Addendum No. 1

RE: Contract ID C203198

Brunswick, New Hanover Counties (R-2633BB)

US-17 (Wilmington Bypass) From SR-1430 (Cedar Hill Road) To
West Of US-421 North Of Wilmington

NOTE: TEMPORARY RAILROAD GRADE CROSSING.

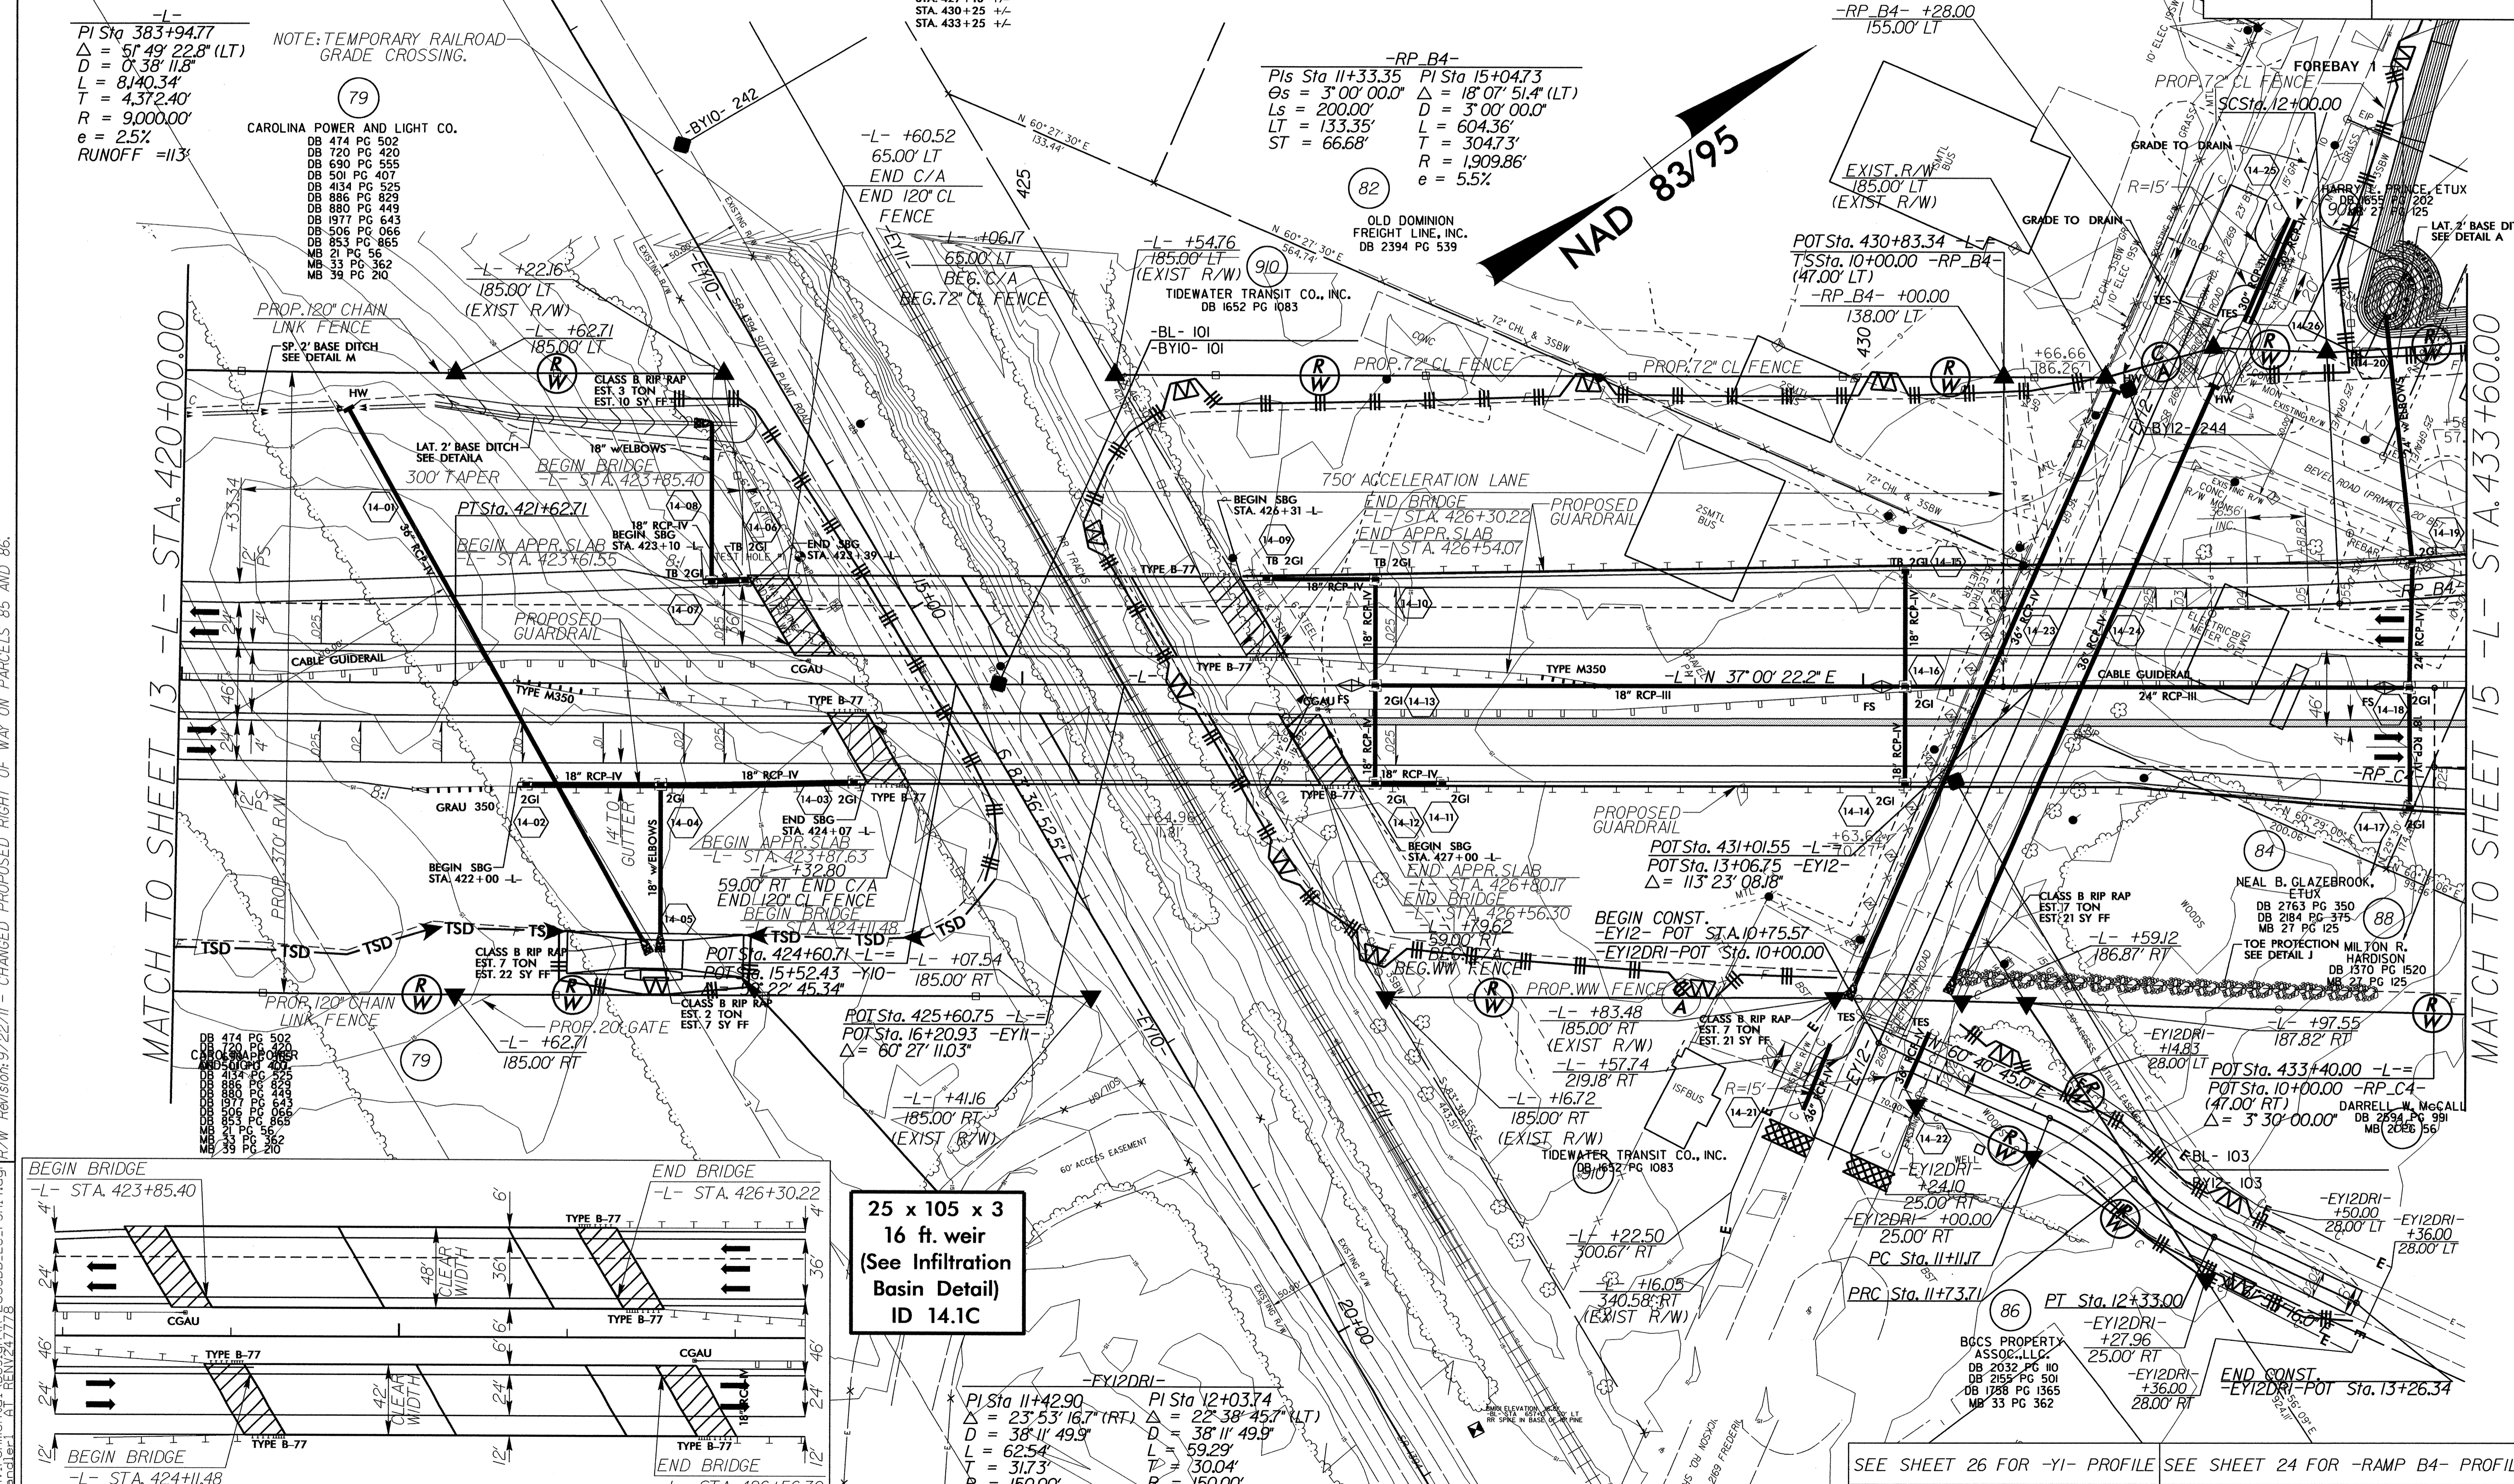
On Sheet No. 14 the reference to "Temporary Railroad Grade Crossing" has been removed. Please void Sheet No. 14 in your plans and staple the revised Sheet No. 14 thereto. If the Contractor wants to pursue a temporary grade crossing at this location he must make his own arrangements/agreement directly with the railroad company.
